**PLANNING ACT 2008
APPLICATION BY HIGHWAYS ENGLAND FOR AN ORDER GRANTING
DEVELOPMENT CONSENT FOR THE A303 SPARKFORD TO ILCHESTER
DUALLING
SUBMISSION MADE PURSUANT TO DEADLINE 8**

PLANNING INSPECTORATE REFERENCE TR010036

Action Point 18 (from 23 May Issue Specific Hearing): Applicant and SCC to set out position regarding the temporary possession and compulsory acquisition of rights and any reference to case law

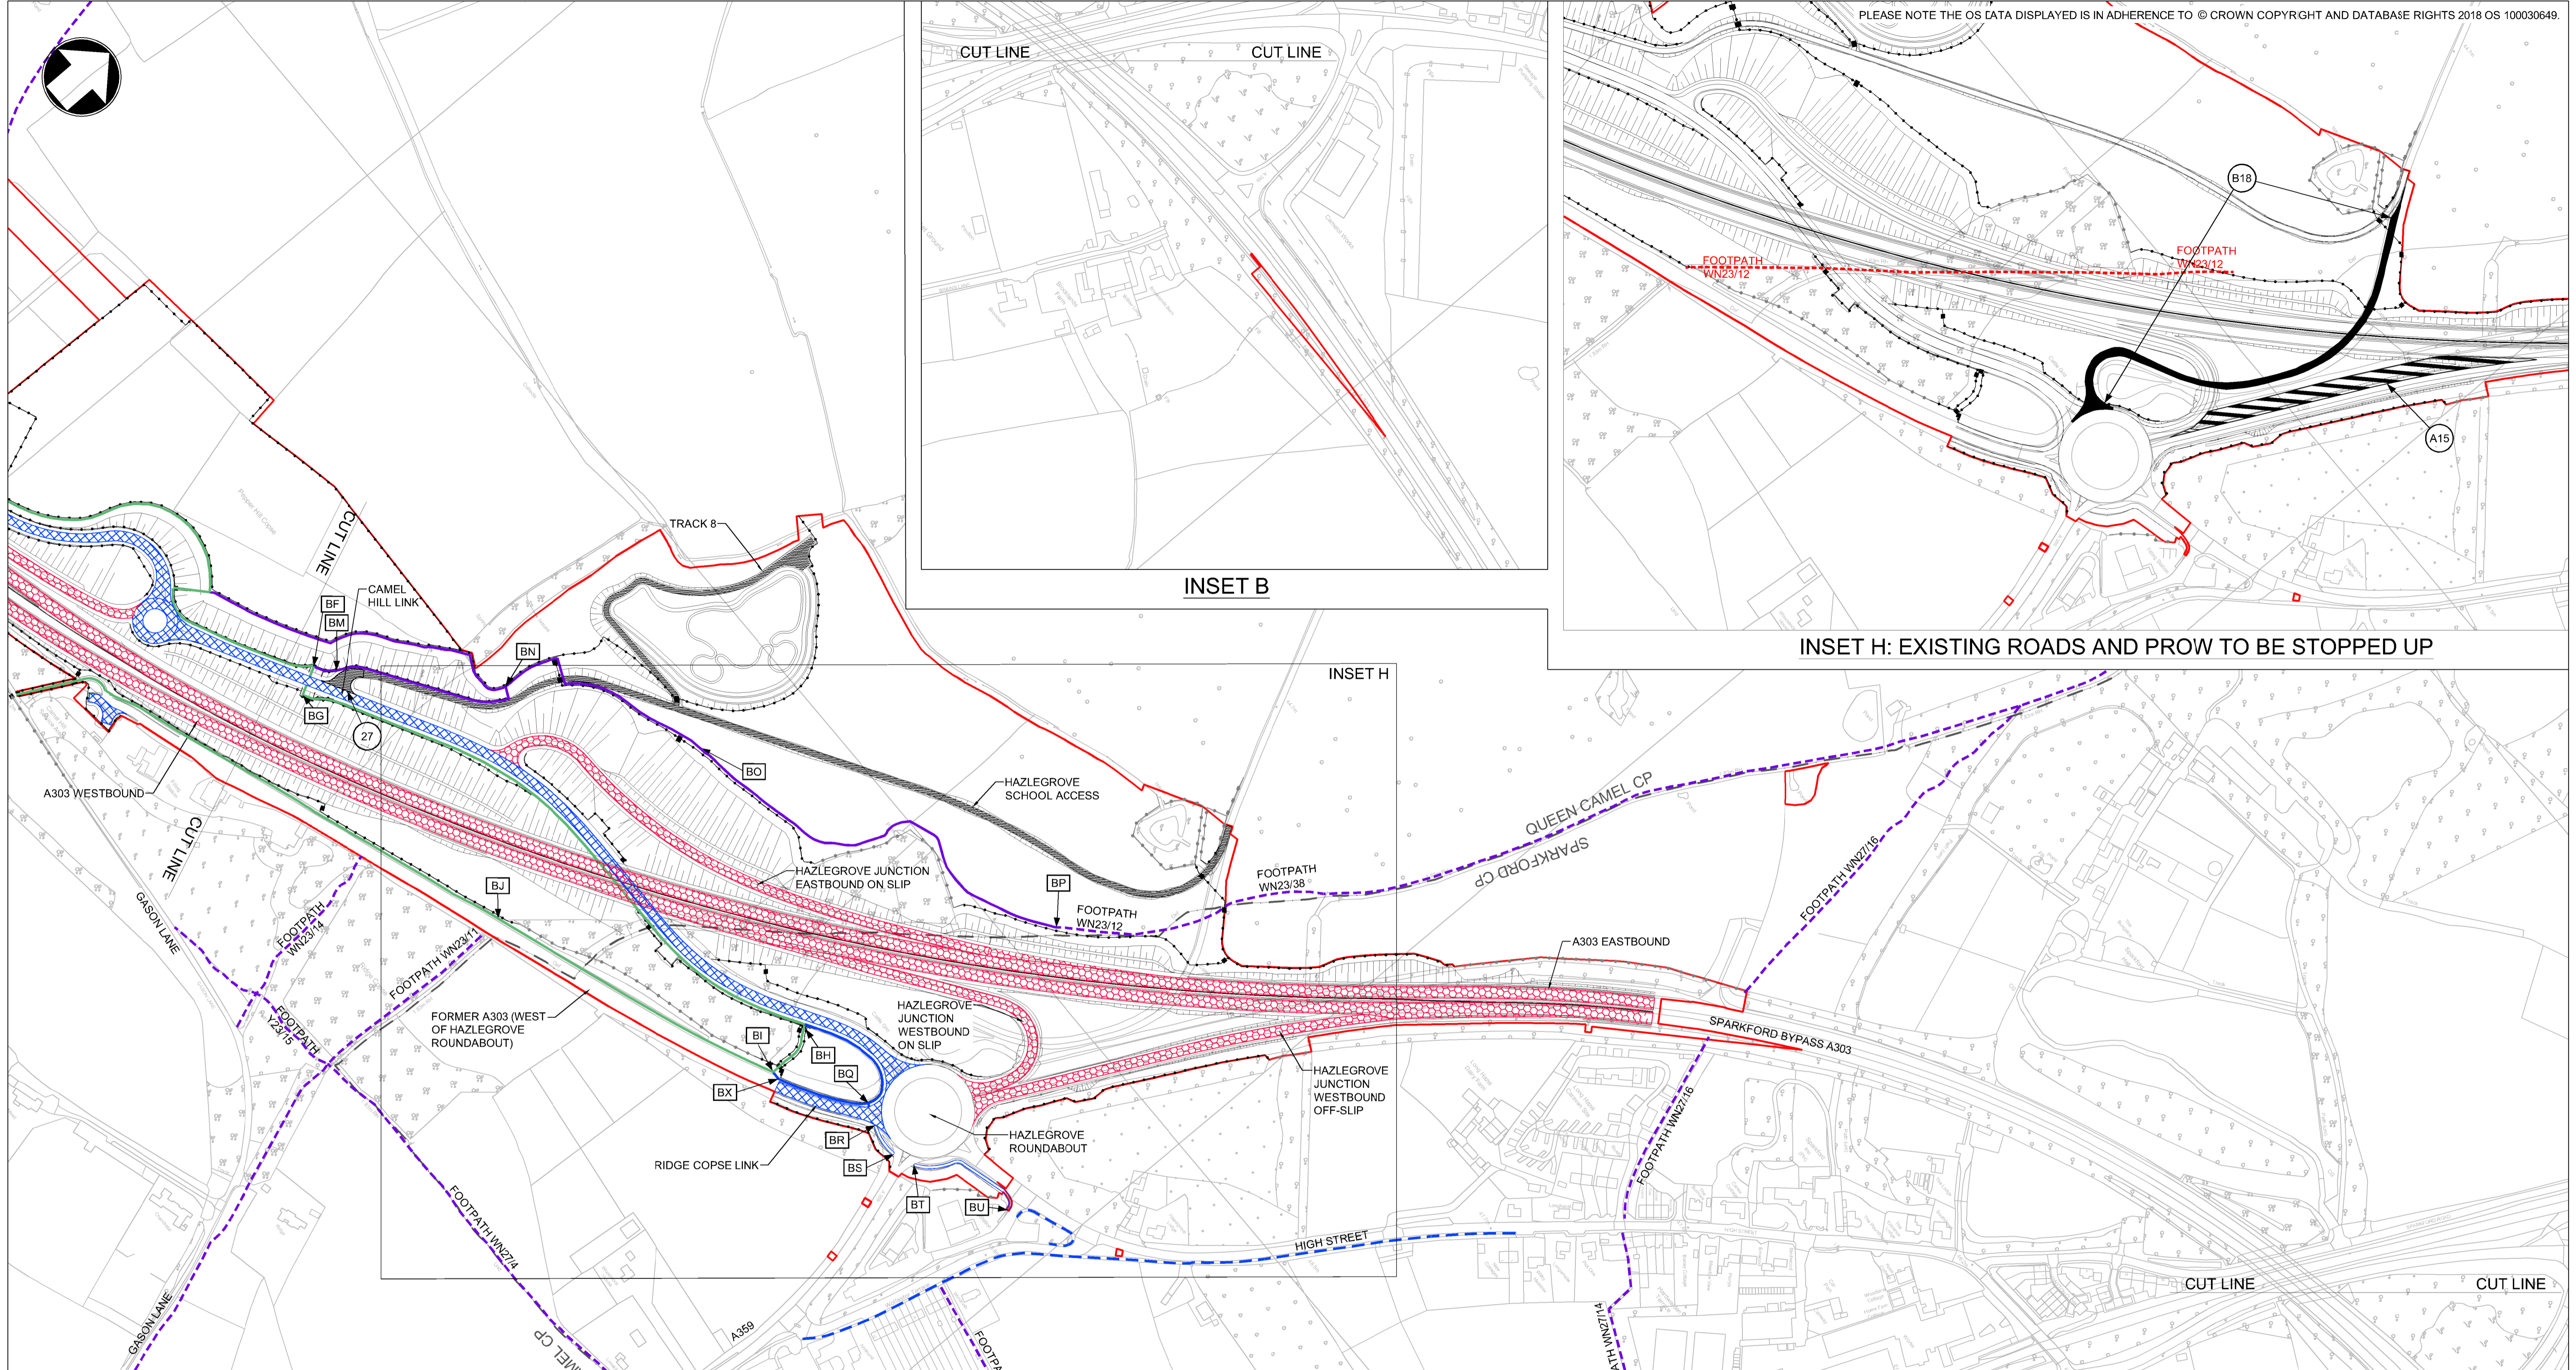
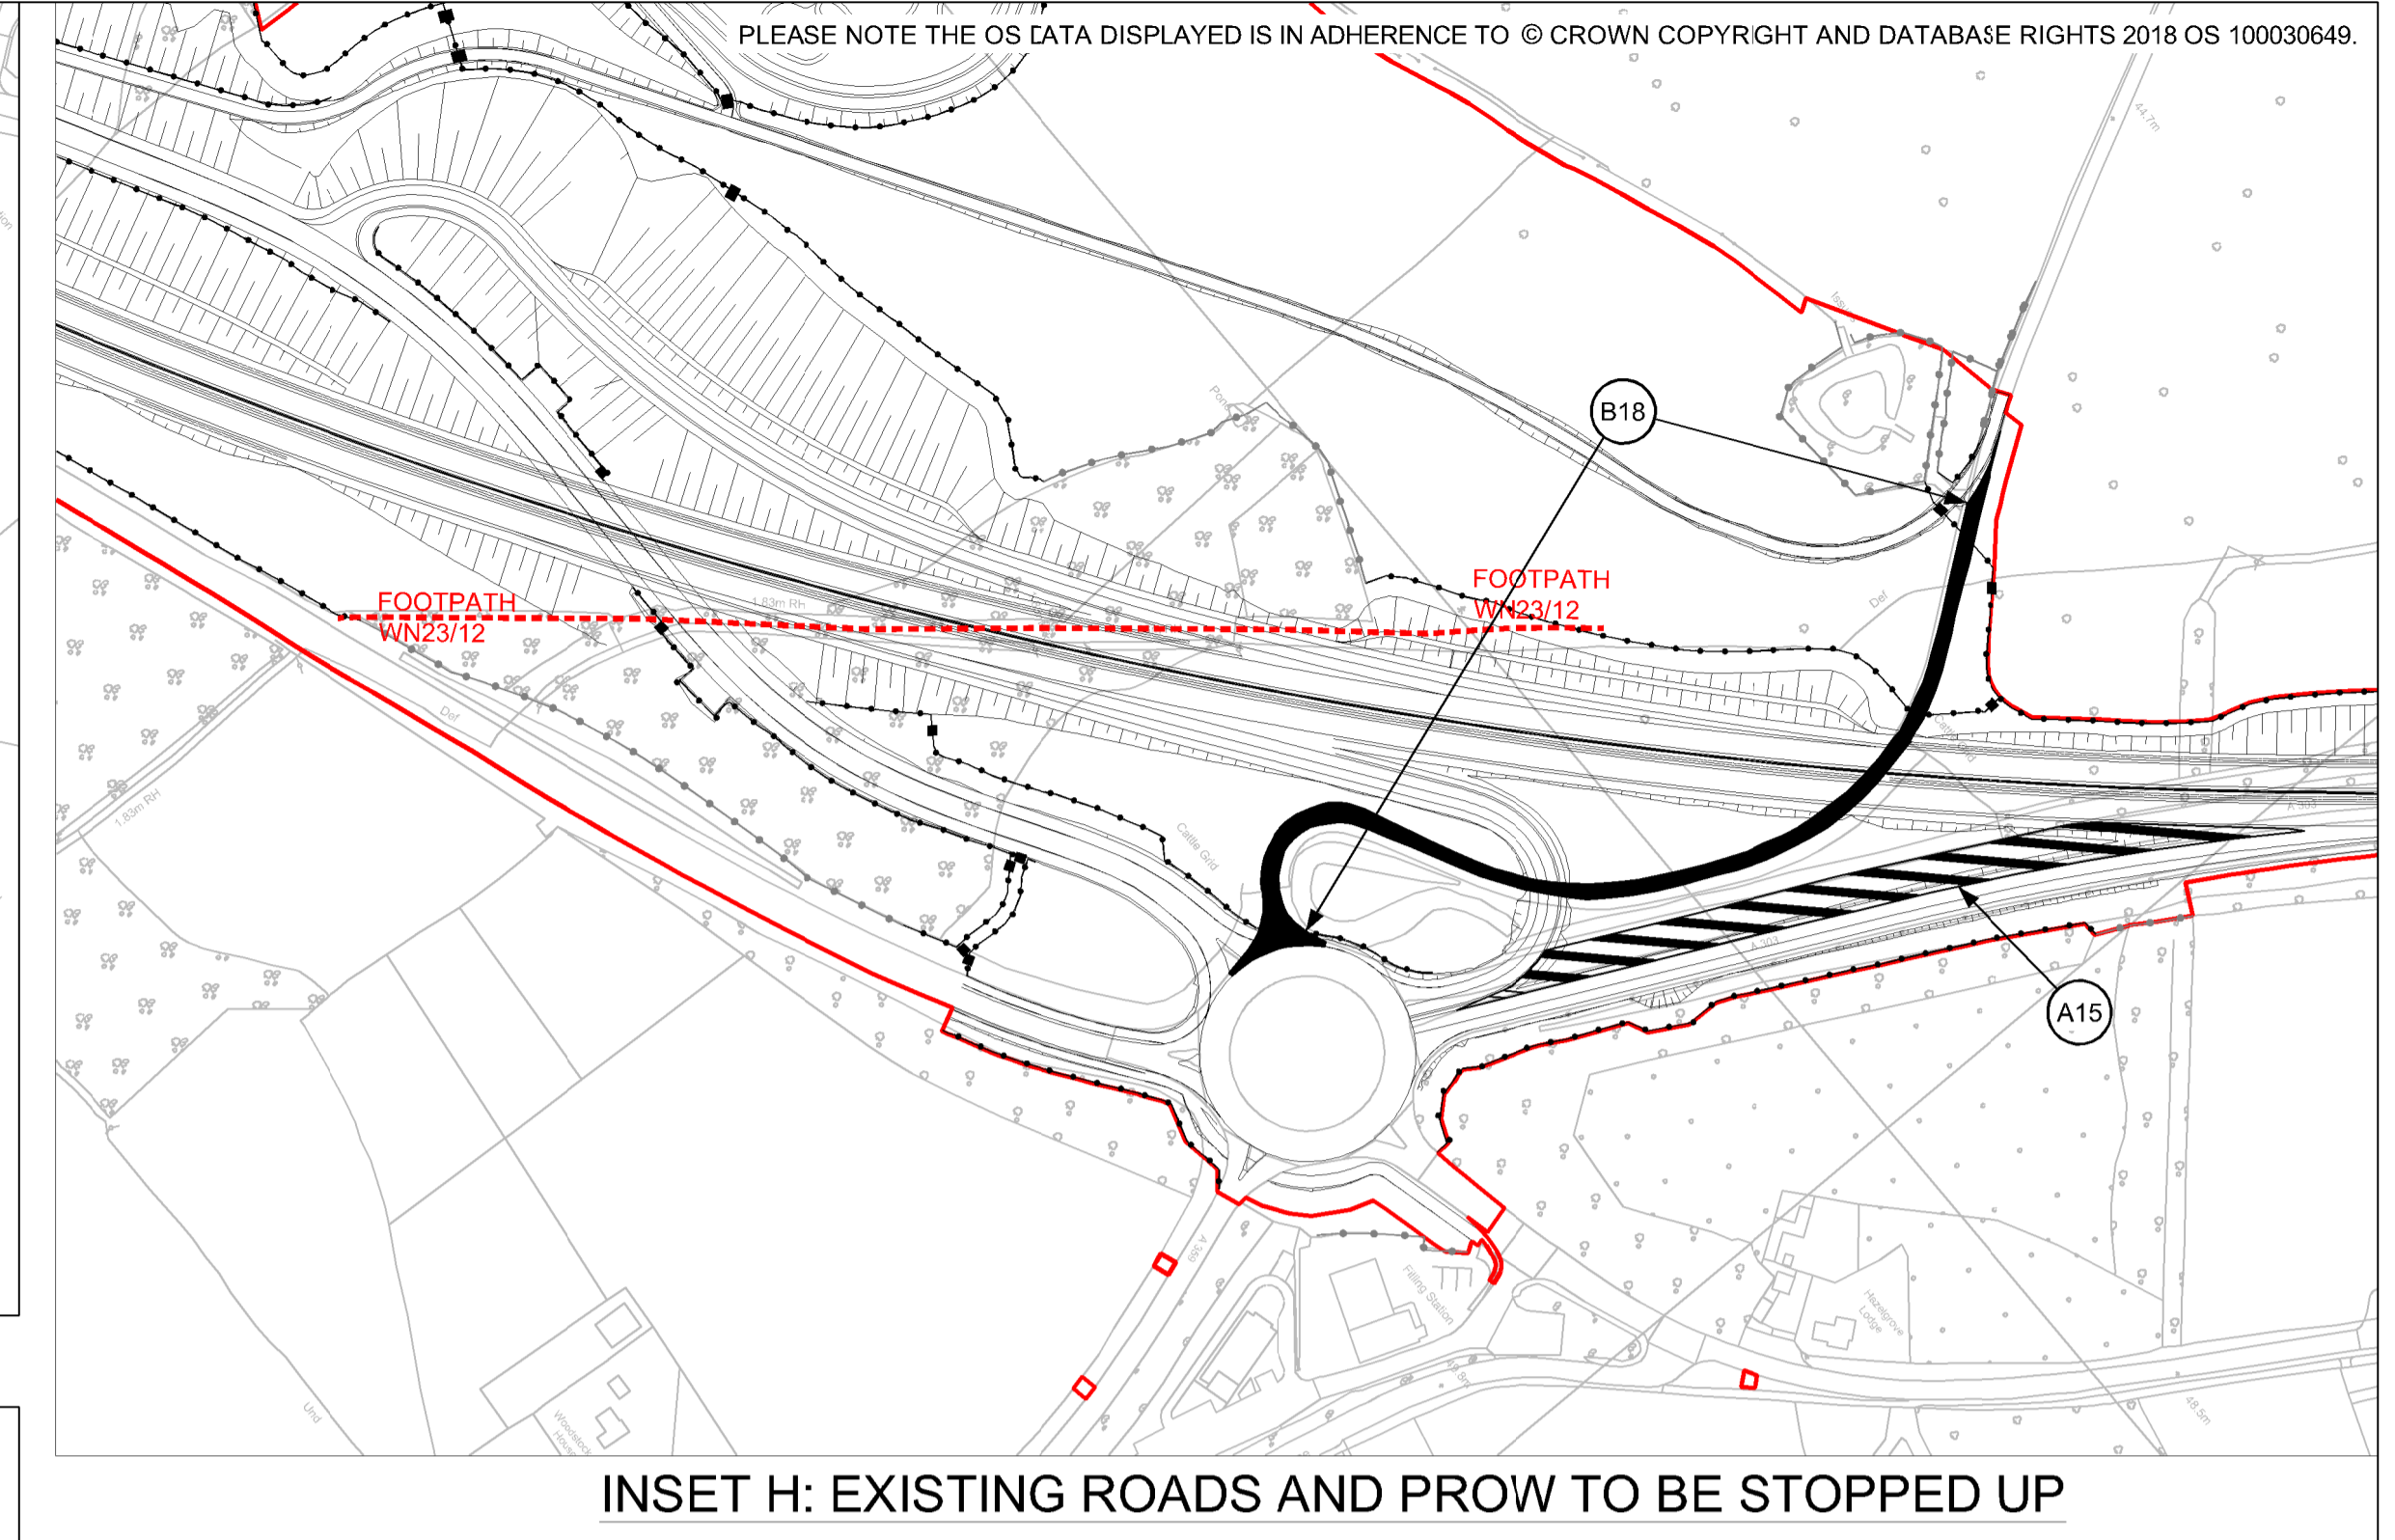
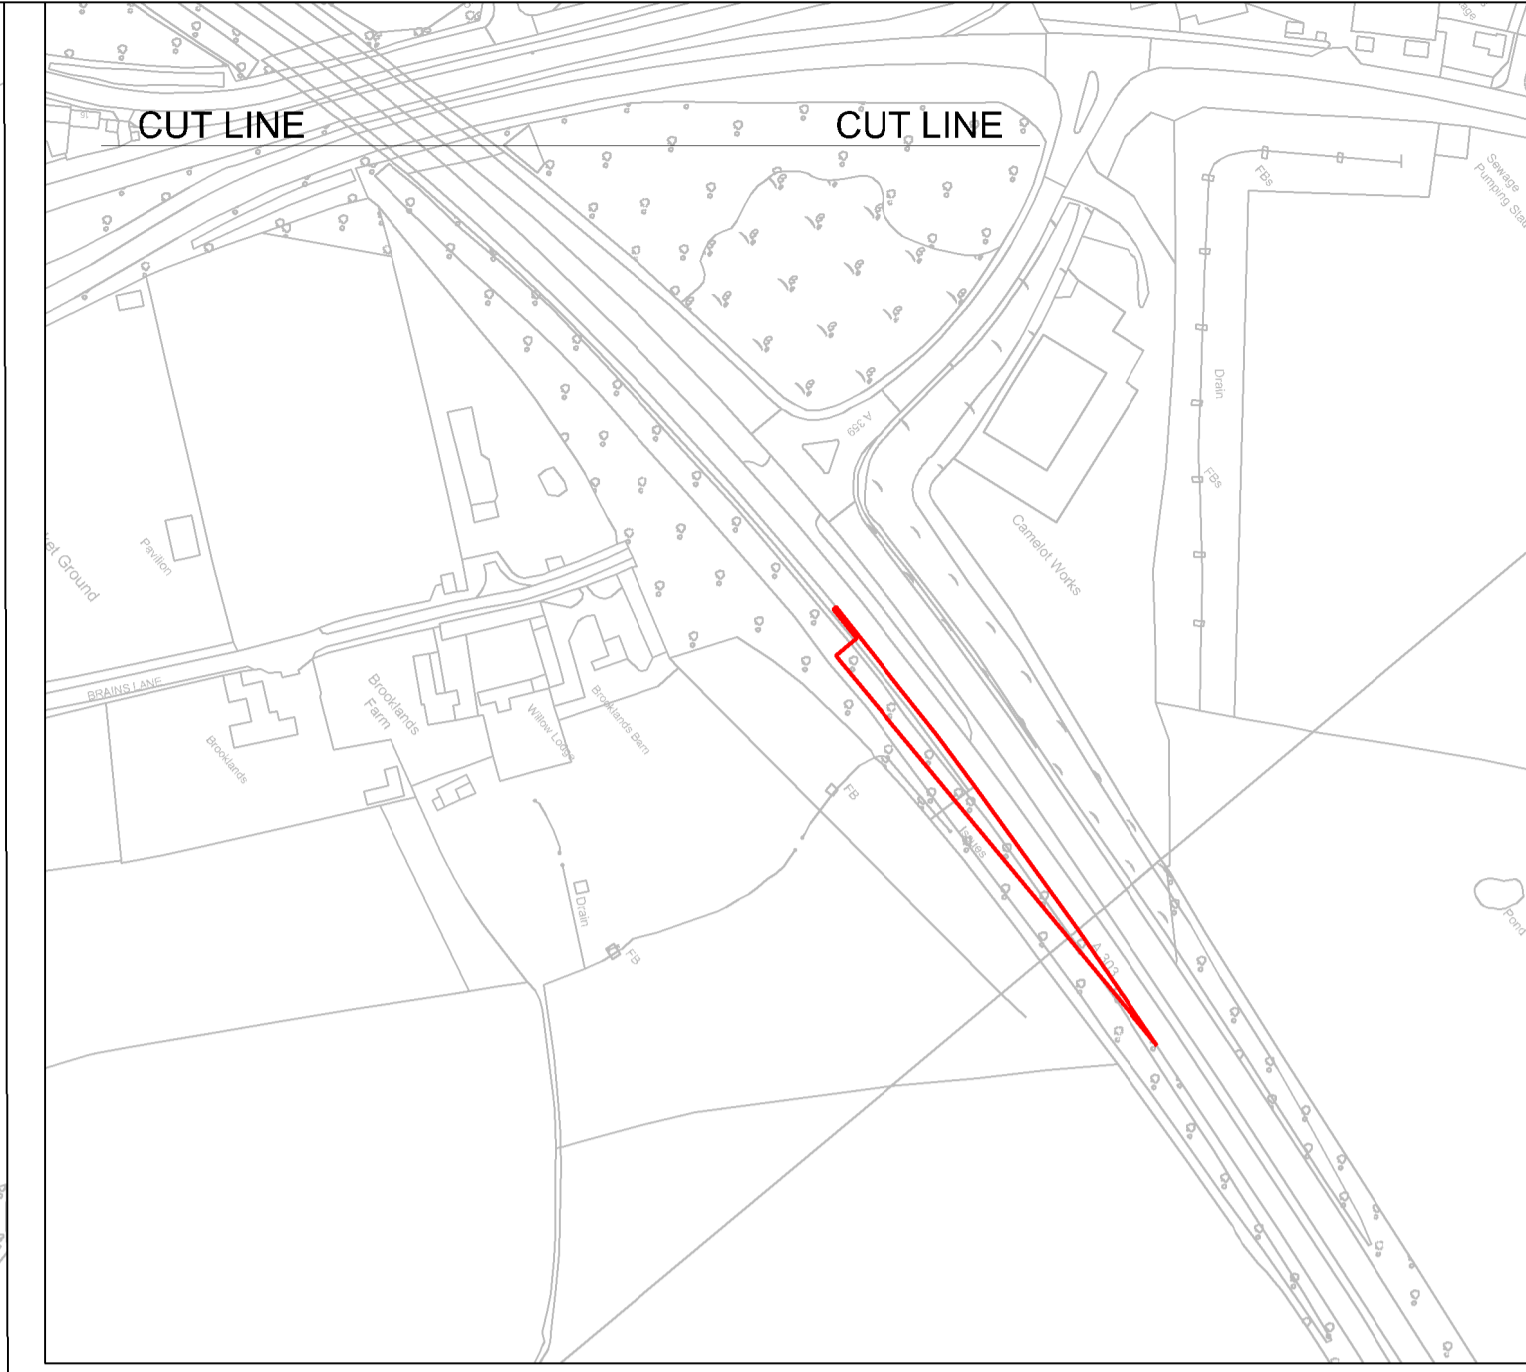
Specifically, 4/1i & 4/1j are within highway limits, but parts of the routes AB-AK and AT-AU on RoW & Access Plans fall outside of the Schedule 7 land.

In the case of AB-AK this may not be an issue as these parts fall within permanently acquired land, but there appears to be a gap on the land plans for a section of AT-AU (see extracts of plans below). This may be a minor drafting error on the RoW & Access Plans, but it does raise the question as to whether the Applicant is relying on existing title for this section to create the rights.

In relation to plot 4/1j in Schedule 7, the new bridleway (AT-AU) is within the highway limits. However, on comparing the RoW & Access Plans with the Land Plans there appears to be a gap between 4/1j and 4/7a where there is no acquisition/possession. It is not clear whether the Applicant may already own this land, and clarification is required.
